ARCHITECTURAL INNOVATIONS, P.S.
Forward Thinking Design Solutions For Your Environment

Nov. 2, 2022

RE: AI Job #21076

Permit: 2210-120, 3036 67th Ave SE

SHEET A7

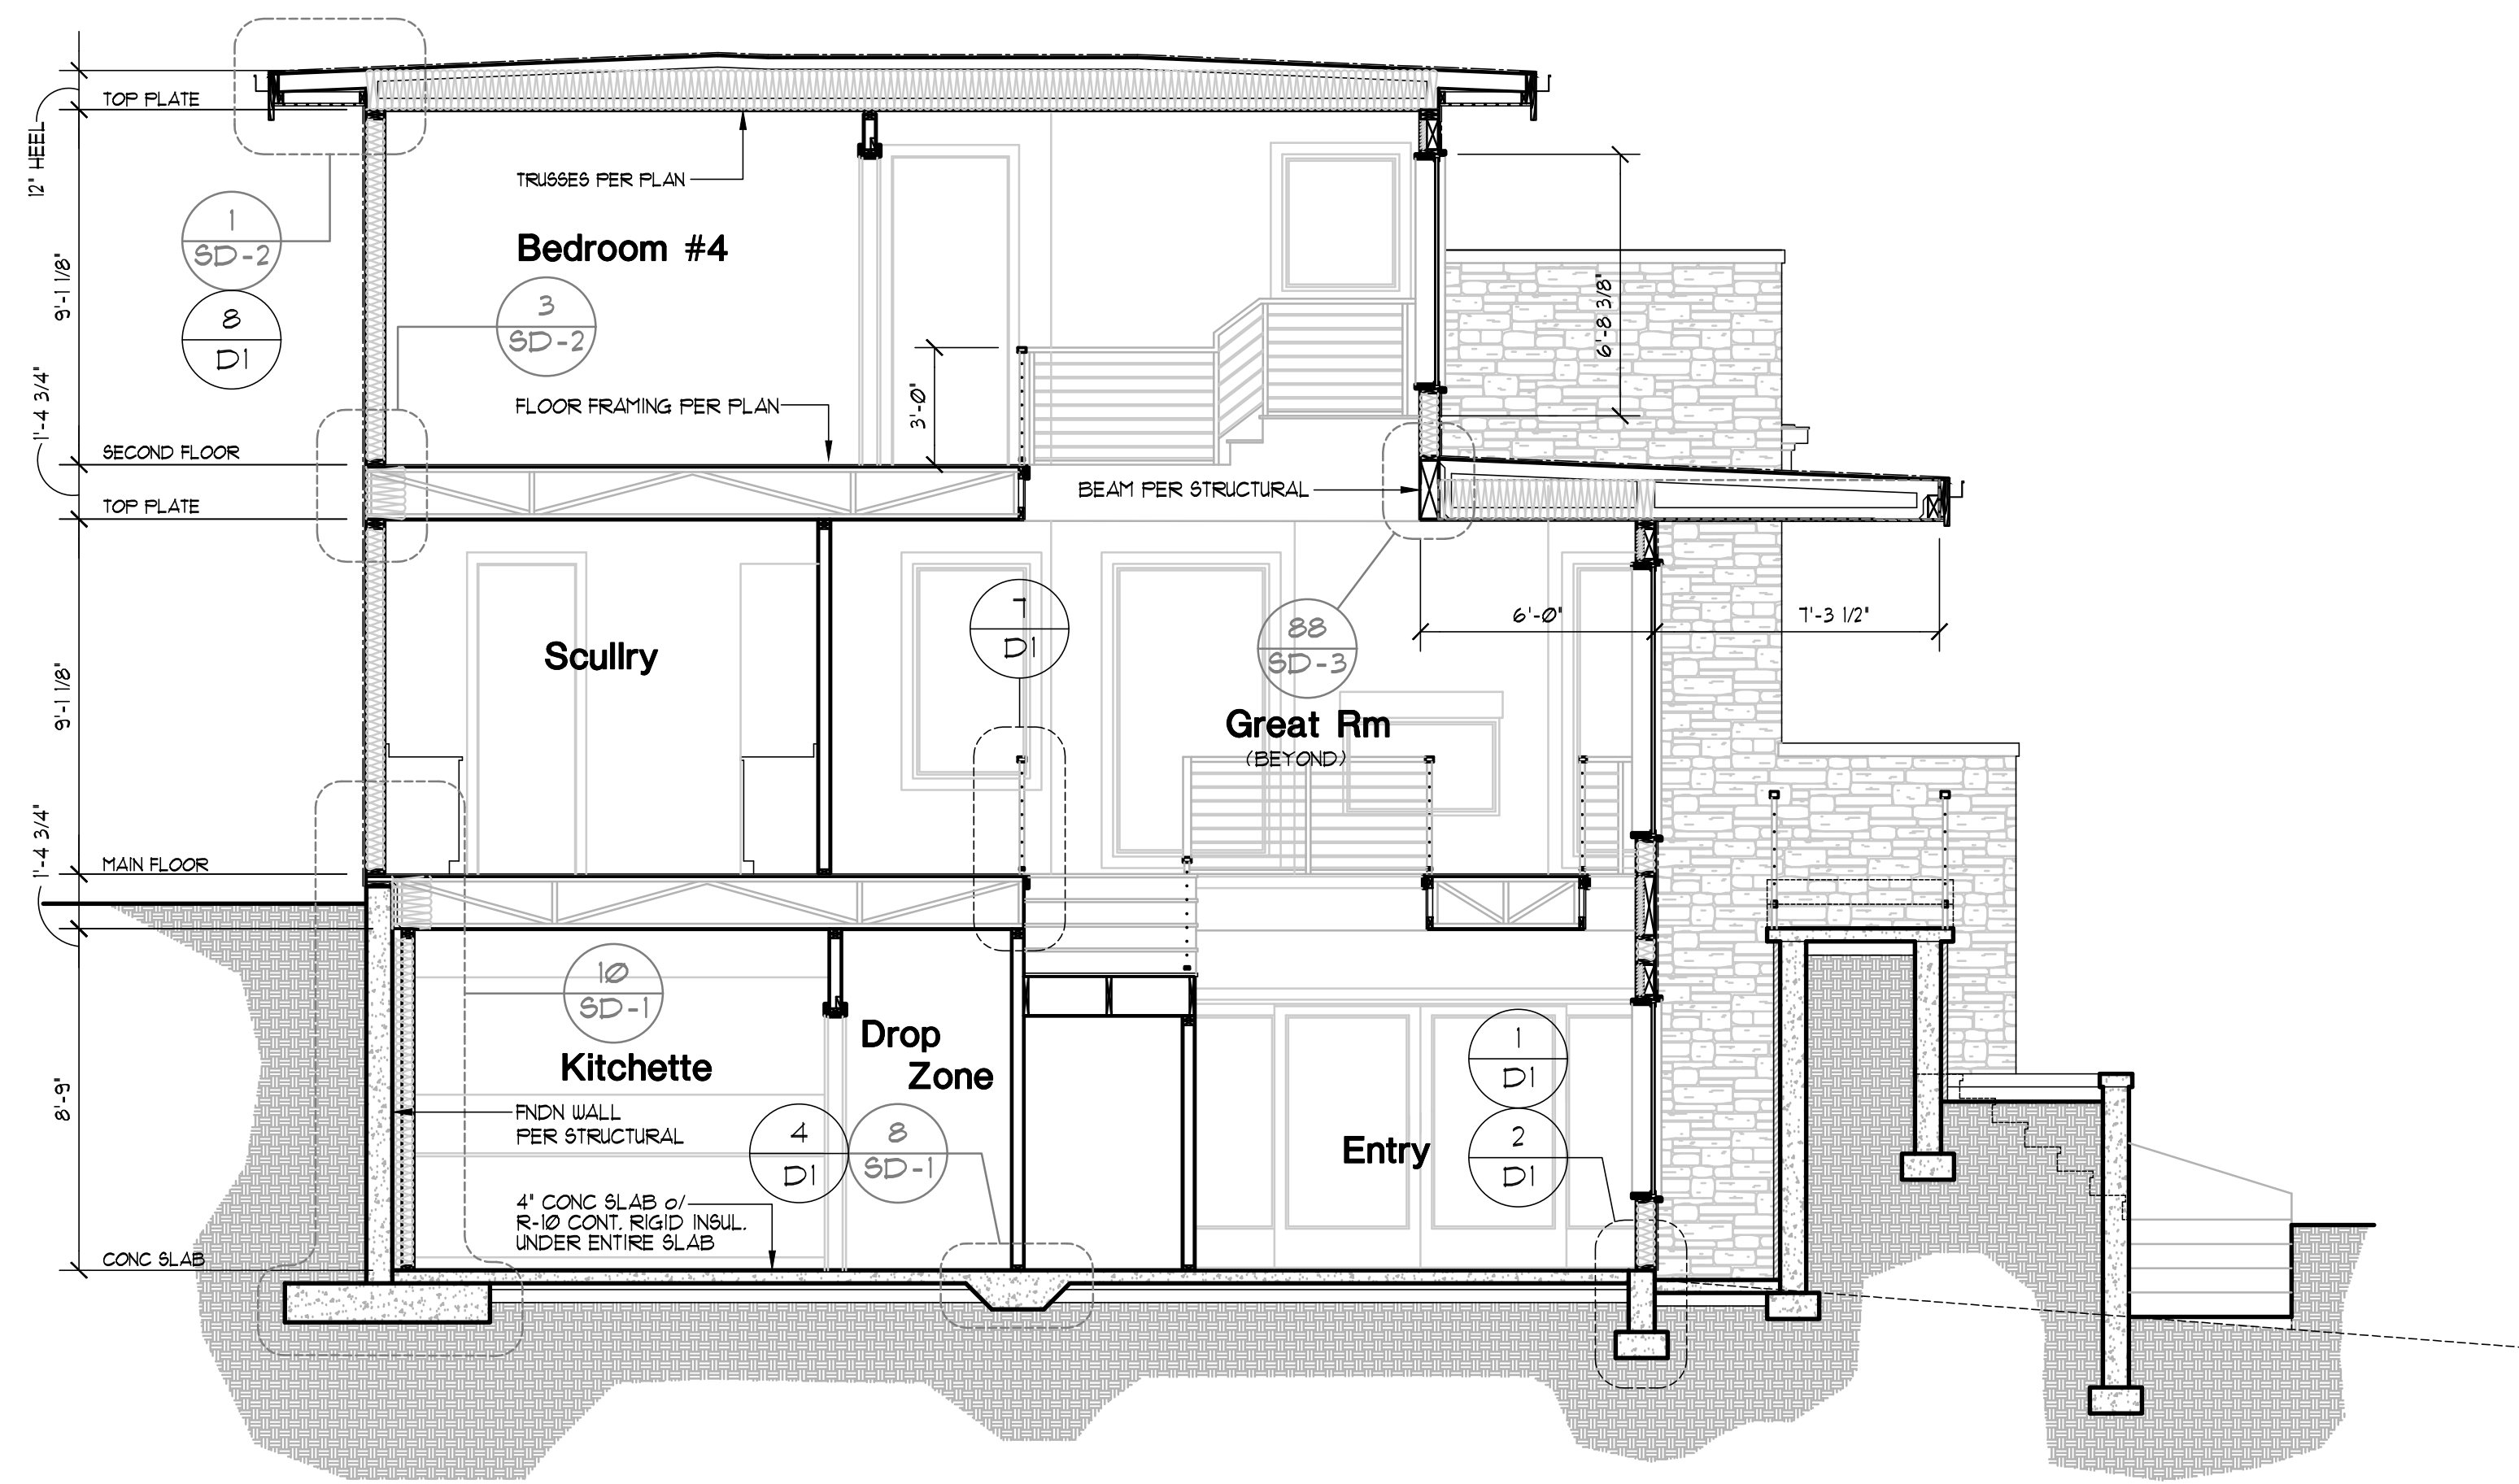
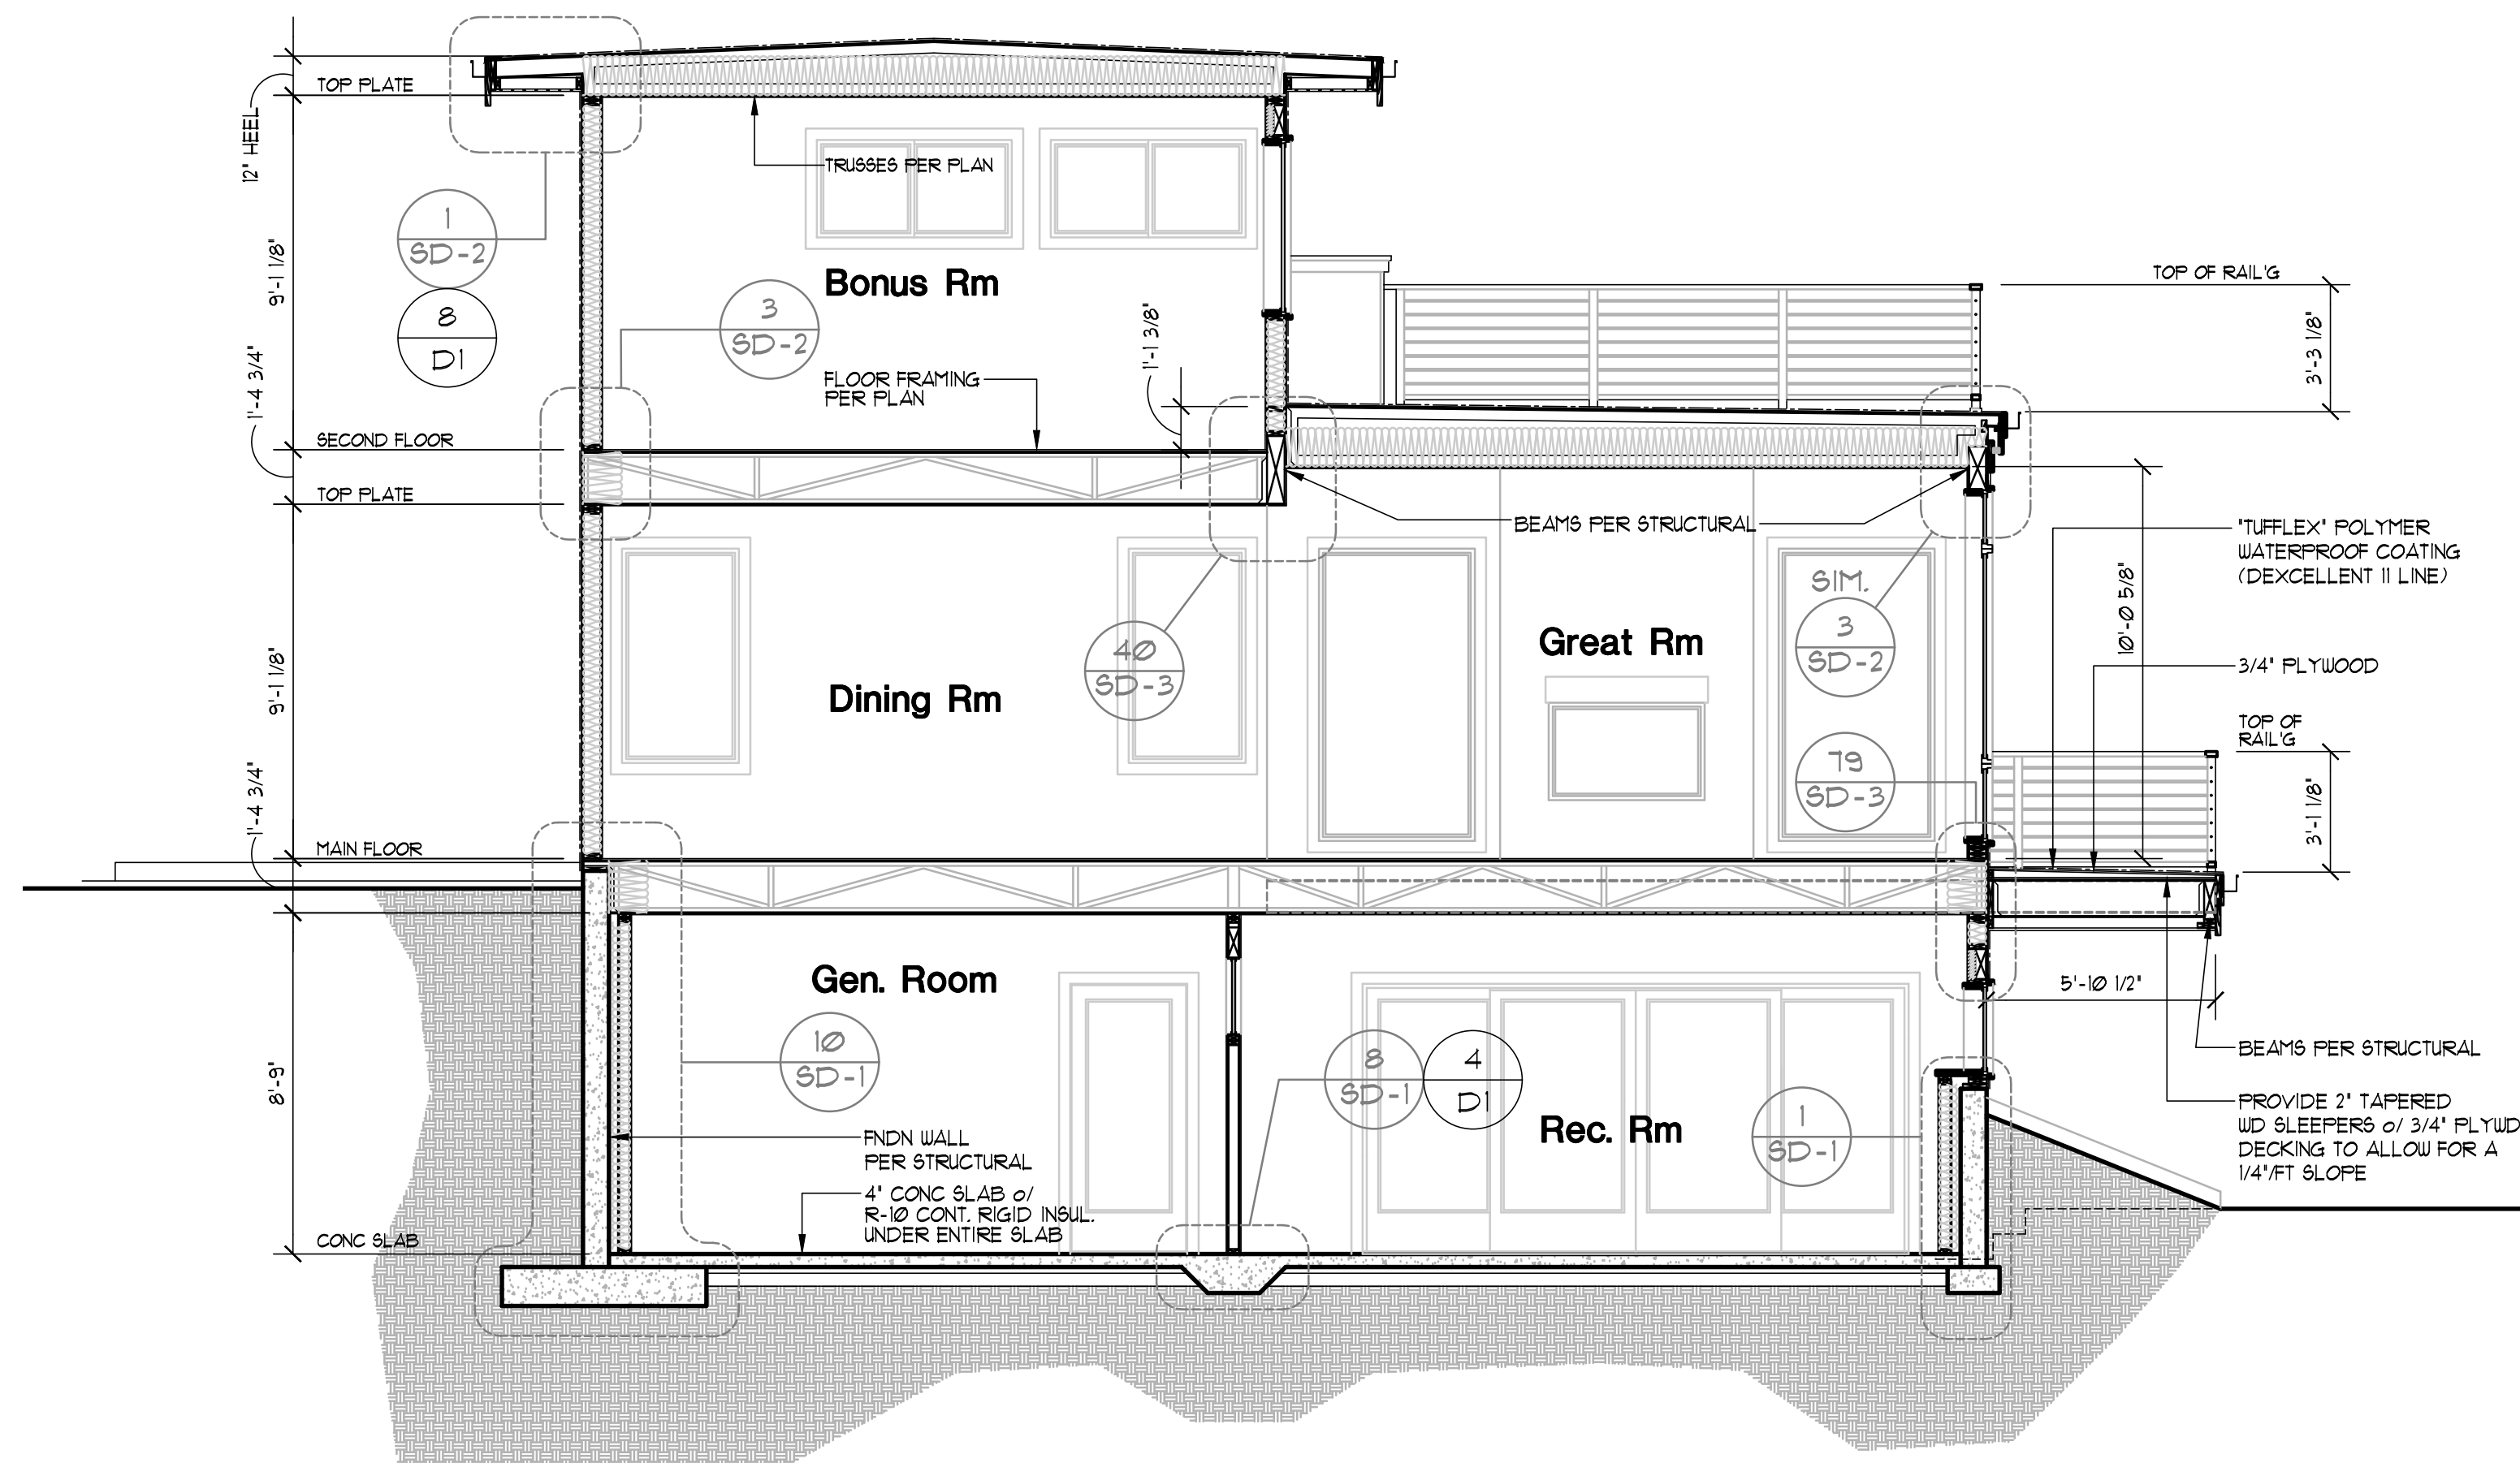
1. Indicate critical areas and buffers (wetland, watercourse, steep slope)
(On sheet A1.1, the extents of the critical area has been identified and labeled with a cross hatched pattern.)
2. Indicate existing grade and finished grade
(On sheets A6 & A7, the existing grade has been shown and identified with a bolder dashed line)
